Yorkshire Green Energy Enablement (GREEN) Project

Document 9.1 Change Application: Report on Proposed Changes

**Final Issue A
July 2023**

Planning Inspectorate Reference: EN020024

9. My client proposes an alternative construction access as shown on the plan.

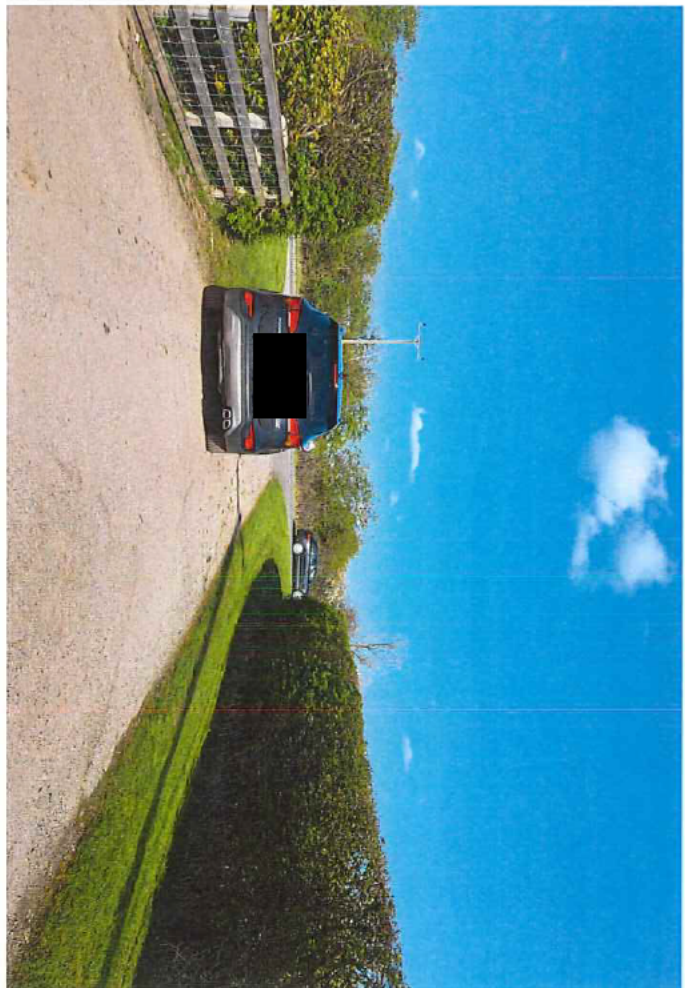
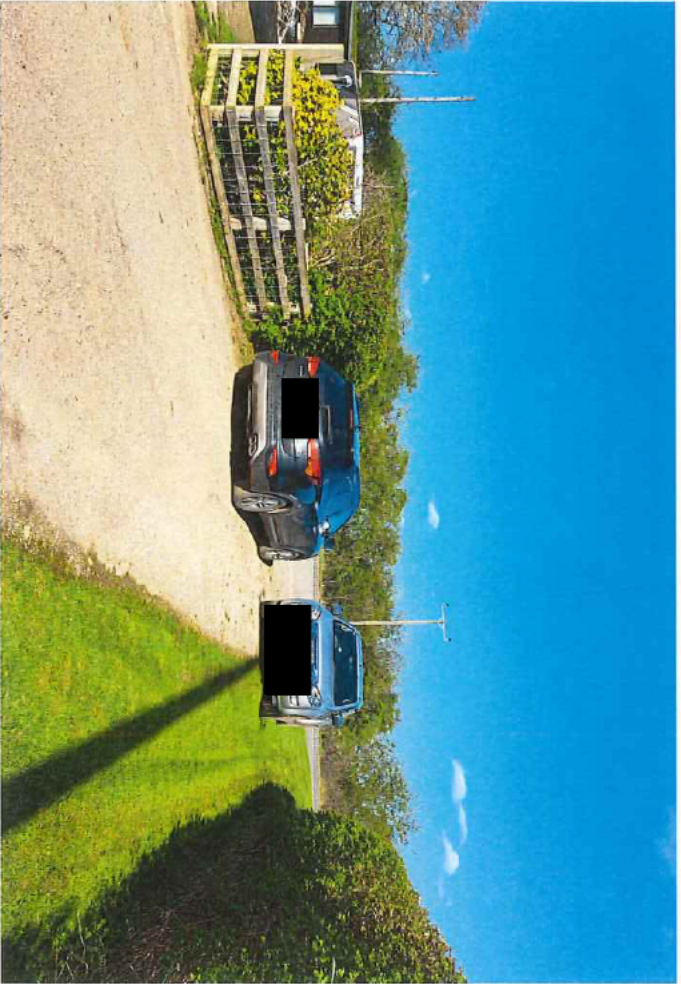
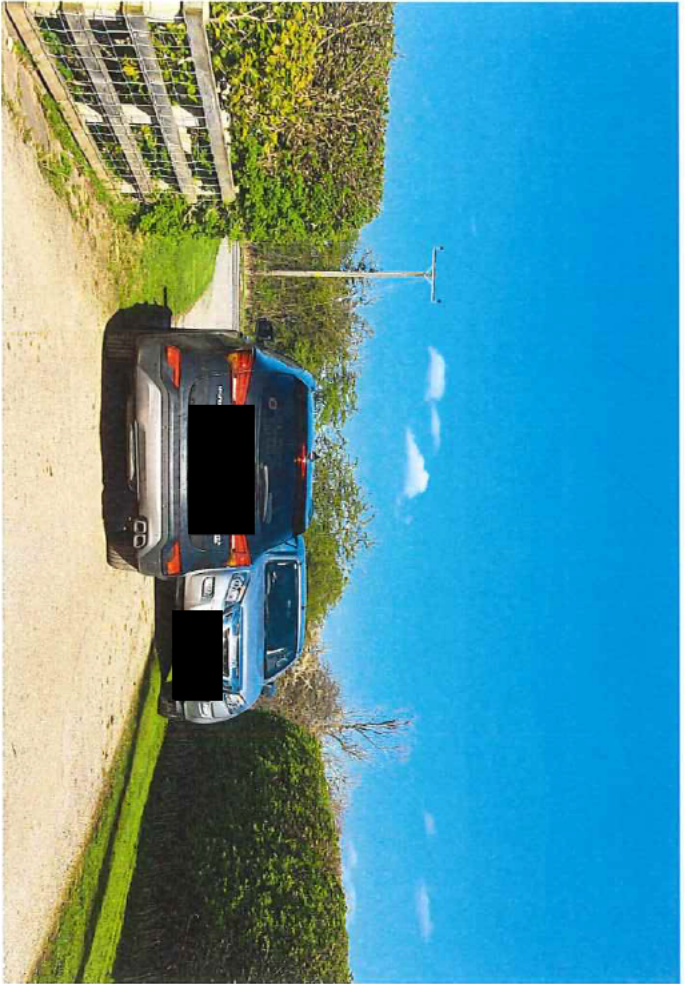
4.1.1 This change relates to the construction access to pylon SP005. Currently the access point is off the A19 (access AP93 on the **Access Rights of Way and Public Rights of Navigation Plan Section B (Document 2.7.2) [APP-027]**), and along an existing farm access track which passes New Farm Cottages and a number of agricultural buildings. This would result in the need to underground an existing utility (Work No. U4) across the A19, to allow suitable space for construction traffic to access the track; and would require the removal of sections of an existing hedgerow to accommodate the widening of an existing bellmouth, and the widening of the existing access track to provide passing places.

4.1.2 The proposed change is to utilise an access haul road arrangement from SP004 so construction vehicles will travel from the Overton Substation site to SP004, and then continue along an access haul road to SP005. The change will require a temporary bridge over Hurns Gutter for construction only, which will be subject to a land drainage consent under Section 23 of the Land Drainage Act 1991. The need for such a consent is already considered within the Details of Other Consents and Licences document **(Document 7.3) [APP-204]**, and therefore no changes to this document are required.

4.1.3 The change proposed would remove the need to undertake utility undergrounding works (Work No. U4) and would also remove the need for hedgerow removal associated with widening the bellmouth and creating vehicle passing places down the existing track and the associated visibility splay for the bellmouth.

- 4.2.1 The change is proposed in response to Written Representations submitted at Deadline 2 from Stephenson's Rural LLP on behalf of the owners and occupiers of New Farm Cottages [REP2-132] within which they expressed concerns over temporary and permanent rights for construction traffic being granted over the access track to the front of their residential properties, as well as potential conflict with their parking arrangements and construction vehicle access. Concern was also expressed in relation to the impact of the vehicles passing their properties, such as dust being generated.
